From: Laura Gibbons <Laura.Gibbons@arun.gov.uk>
Sent: 03 November 2020 13:33
To: Planning.Responses <Planning.Responses@arun.gov.uk>
Cc: Simon Davis <Simon.Davis@arun.gov.uk>
Subject: Y/71/20/RES

Engineers Comments Regarding Surface Water Drainage

Reserved Matters Comments

Rev	Amendments	Drn	Chk	App	Date
Scale	@A3	Date	SEP 2020	Designed	AK
Drawn	AK	Checked	SW	Approved	SW
Job No	19-156	Drawing No	YAP-130-27	Rev	-

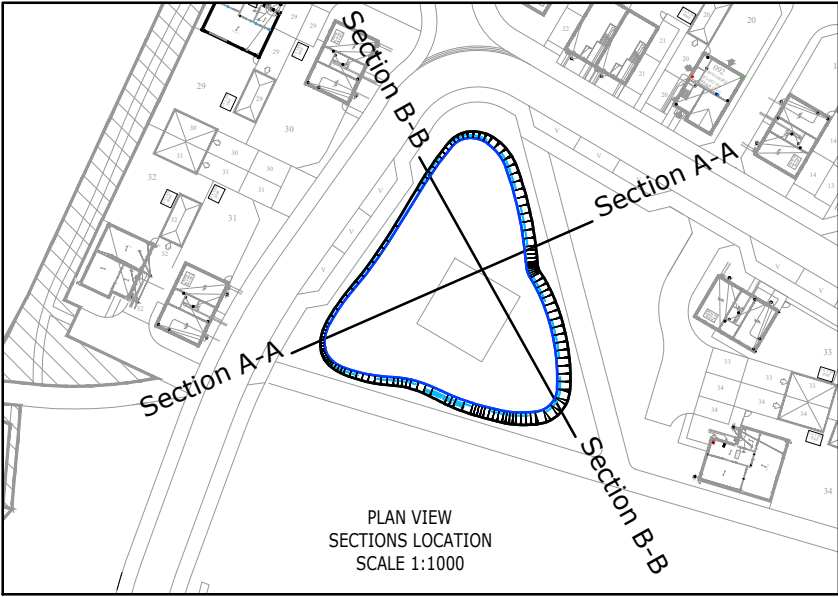
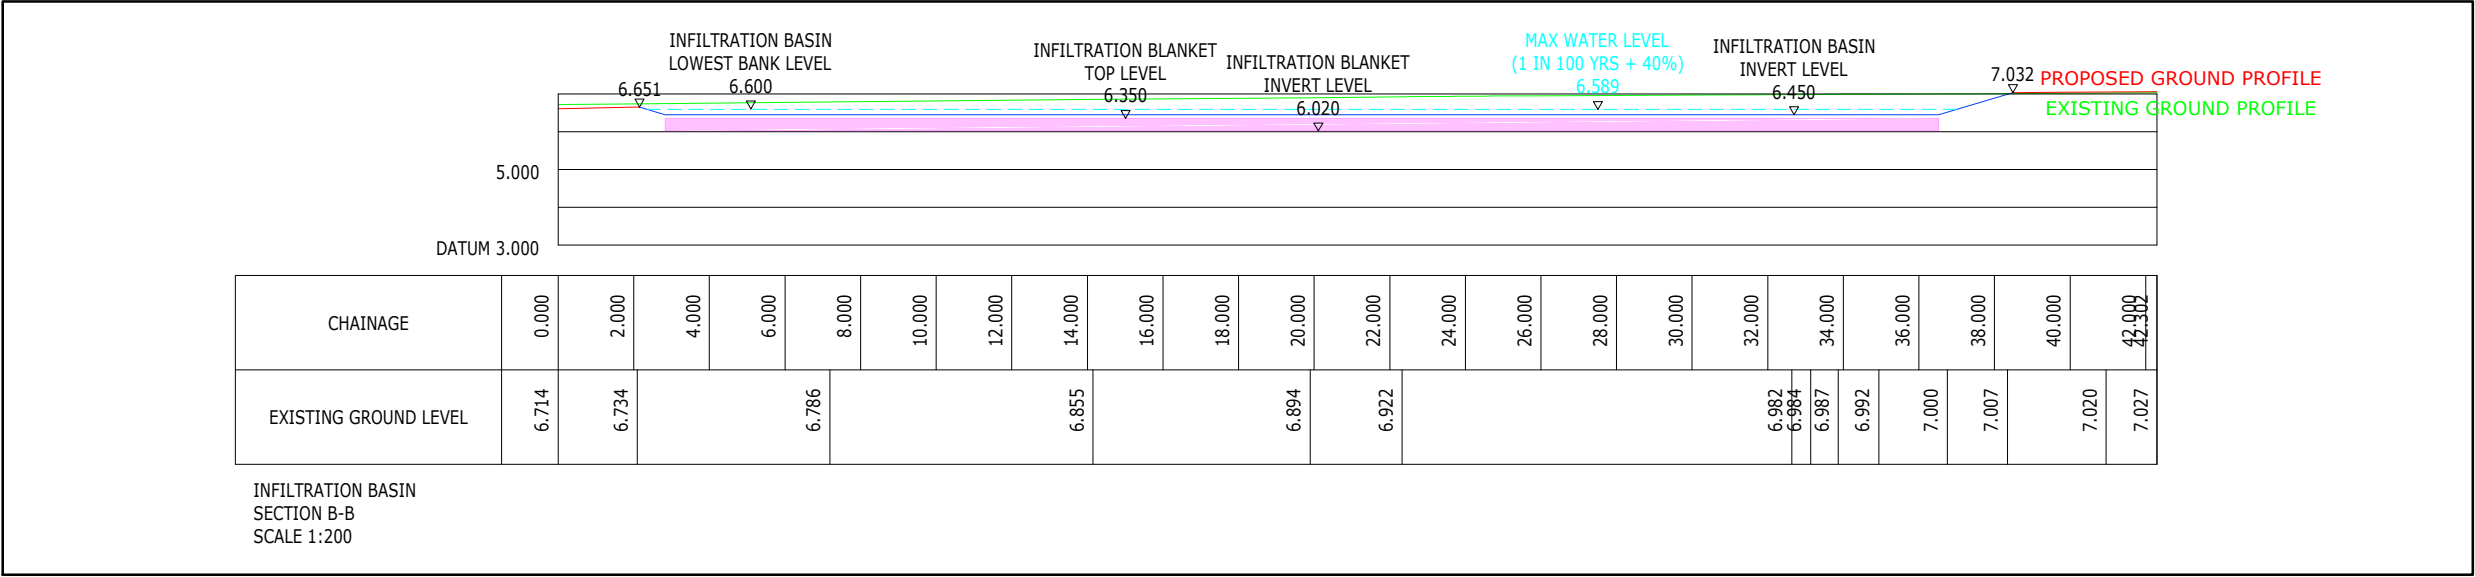
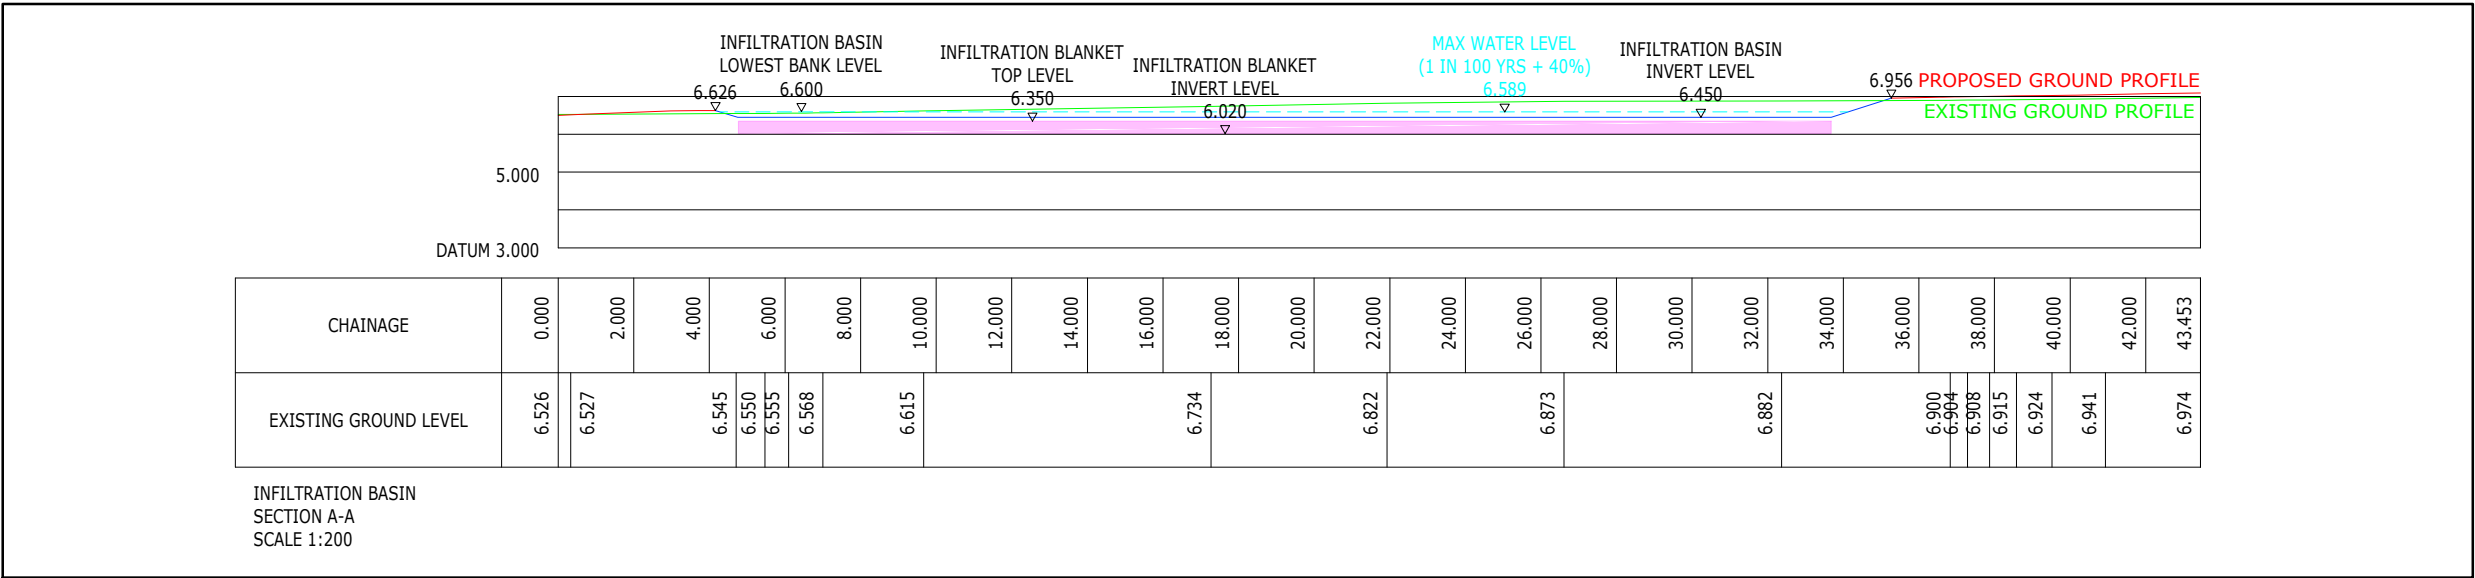
- 1. There appears to be conflict between the proposed public open space and surface water drainage proposals. There is a shallow infiltration basin proposed within the public open space, a LAP is even proposed within the basin. This is not appropriate. It is stated that water will only emerge on the surface here for events in excess of approximately the 1 in 10 year event, however with climate change and more intense storms it can be anticipated that the basin will have water in more frequently than this. The basin fails to meet half drain*

time requirements. With half drain time exceeding 24 hours for the 10 year plus climate change event. This is not acceptable. Water also emerges to the surface of the basin in the climate change event. Given the location of the LAP within the basin, this is not acceptable.

1. *Successful resolution of the above reserved matters points. Awaited.*
2. *Please provide two perpendicular site specific cross sections of the proposed infiltration basin. These should show invert level, maximum water level, bank level, construction including connection between sub-base and basin. Provided, please see comment above.*
